C18D101

Project Title: SILVER OAK SUBDIVISION lot 6 Building Permit #: _____ City Drainage #: C18D101
DRB#: 1010644 EPC#: _____ Work Order#: _____
Legal Description: SILVER OAKS
City Address: 8815 SILVER OAK

**RE: Drainage Resubmittal
Silver Oak Subdivision- (C18D101)
Albuquerque, New Mexico**

RE: Silver Oak Estates | Grading and Drainage Plan | Stamp 10-21-15 (File: C18D101)

SILVER OAK ESTATES MASTER PAVING PLAN	
DATE 12-11-15	BY WCM
SHEET # 5	JOB # 21525-LAYOUT-9-21-15
Rico Grande Engineering 1808 CENTRAL AVENUE SE SUNTEC 501 ALBUQUERQUE, NM 87106 (505) 872-0999	
P.E. #14522 DAVID SOULE

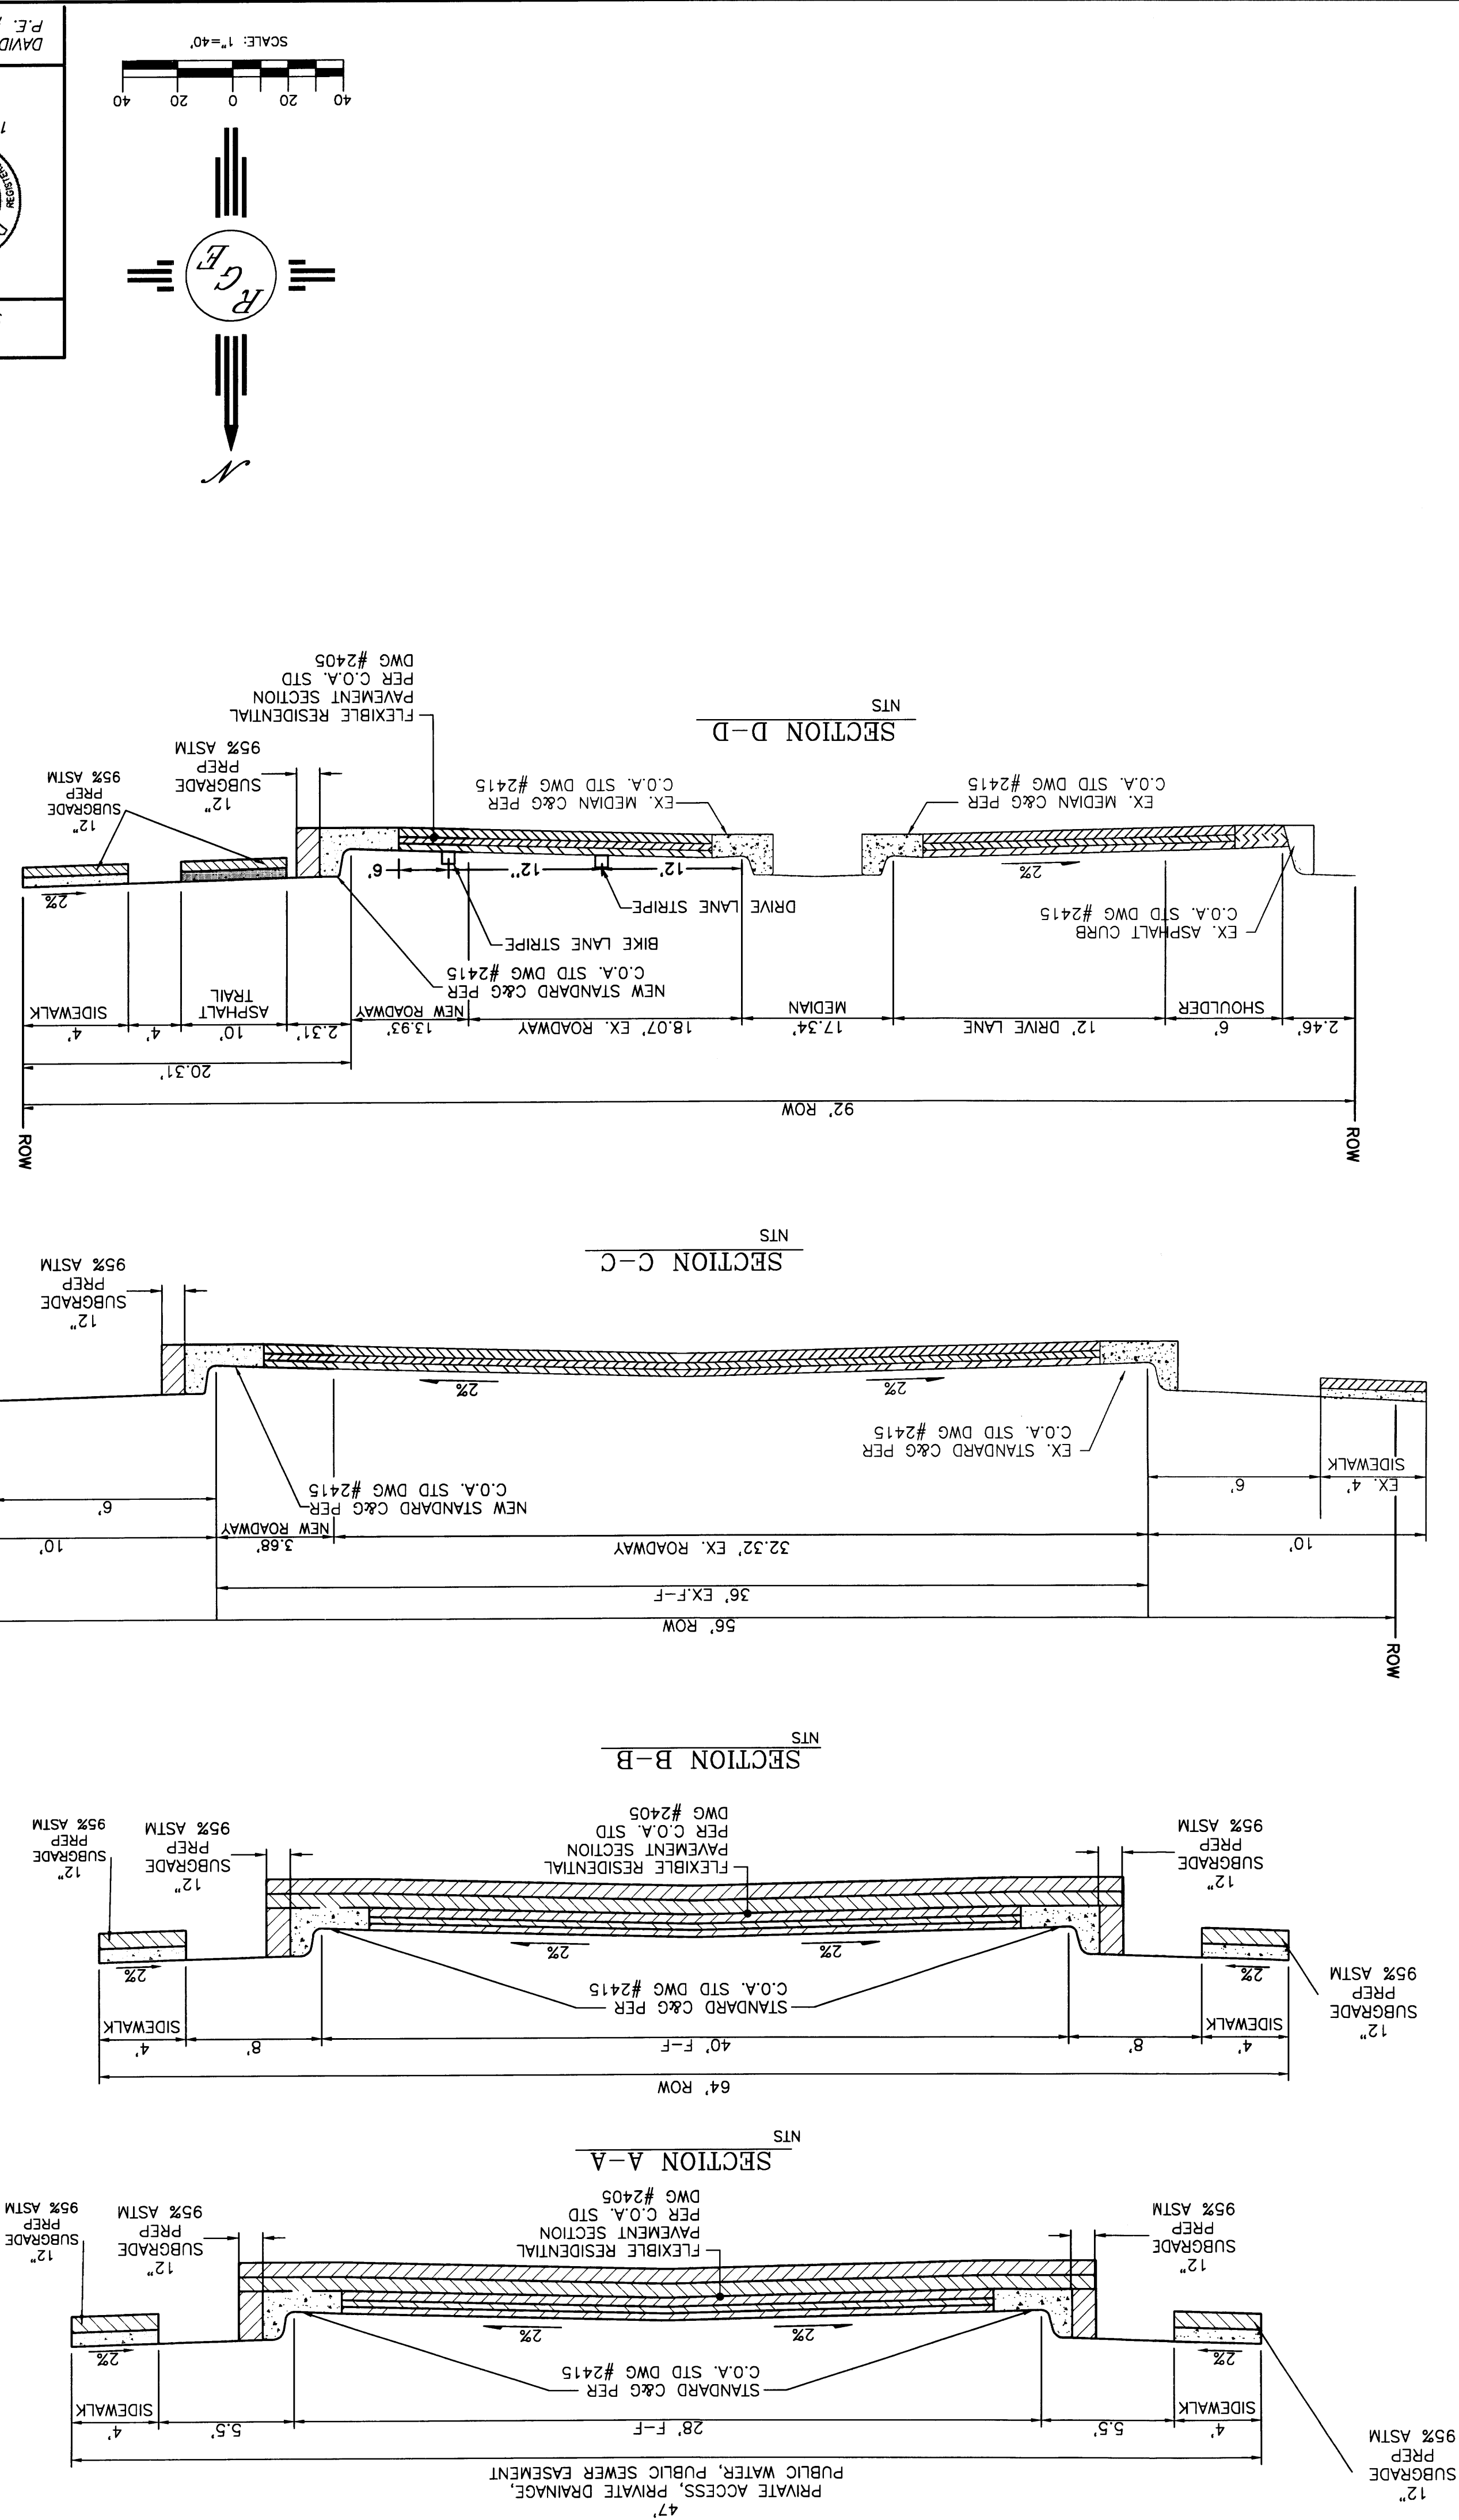
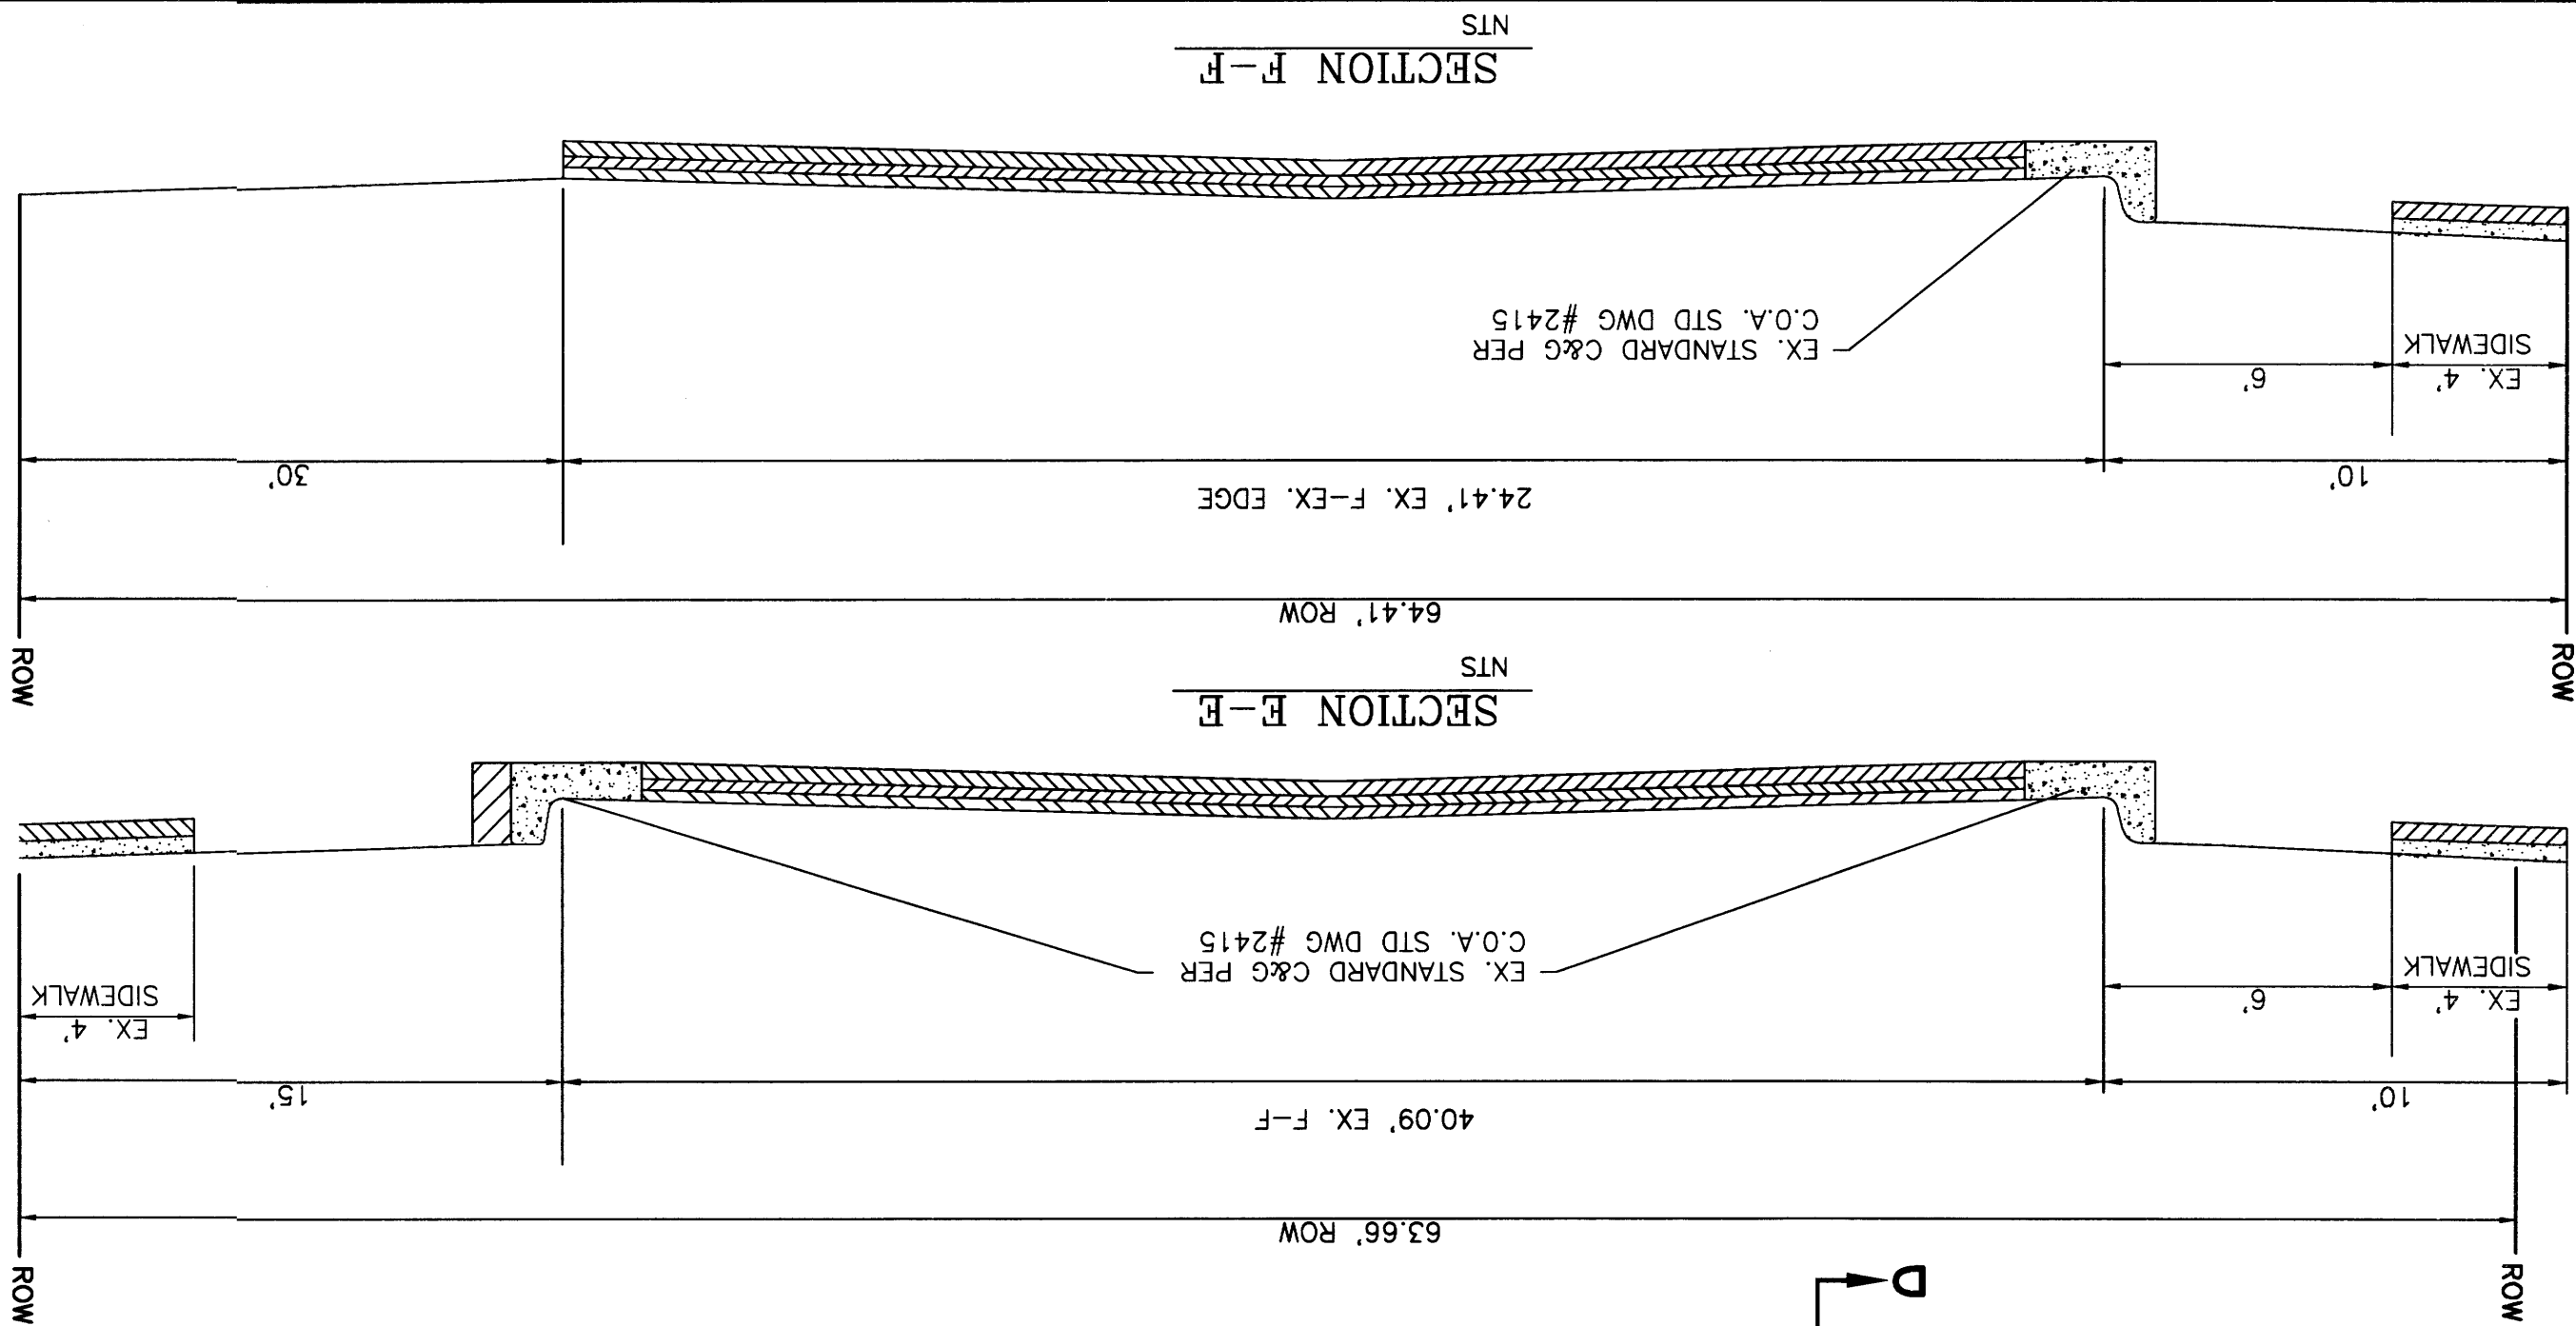
1. Clarify the easement dimensions between the cul-de-sac and Alameda Blvd. The Utility Plan shows a different layout than the Site/Grading Plan.
2. The inlet at the end of the cul-de-sac bulb appears to conflict with the intent to have an access easement to the southernmost lots.

4. The inlets on Oakland and Alameda should have build notes
 - a. The inlet on Alameda is referenced as a single grate Type D inlet to capture flows at the flowline of the roadside swale, but shown differently on the plan. Furthermore, this inlet and pipe needs to be planned with the future expanded section of Alameda Blvd in mind.

2. The inlet at the cul-de-sac conflicts with access to southern lots
We have reduced the inlet to a single A, the inlet is in sump and has double the capacity. This inlet calculation has been included. We have shown the driveways to confirm the geometry

4. Inlets in Oakland and Alameda shall have build notes. The plans and report need to be consistent. The location needs to account for Alameda ultimate section
We have added the build notes and corrected plan to conform to the report. The proposed inlet in Alameda is being placed where an existing stub was constructed. The inlet is being placed at the ultimate curb location.
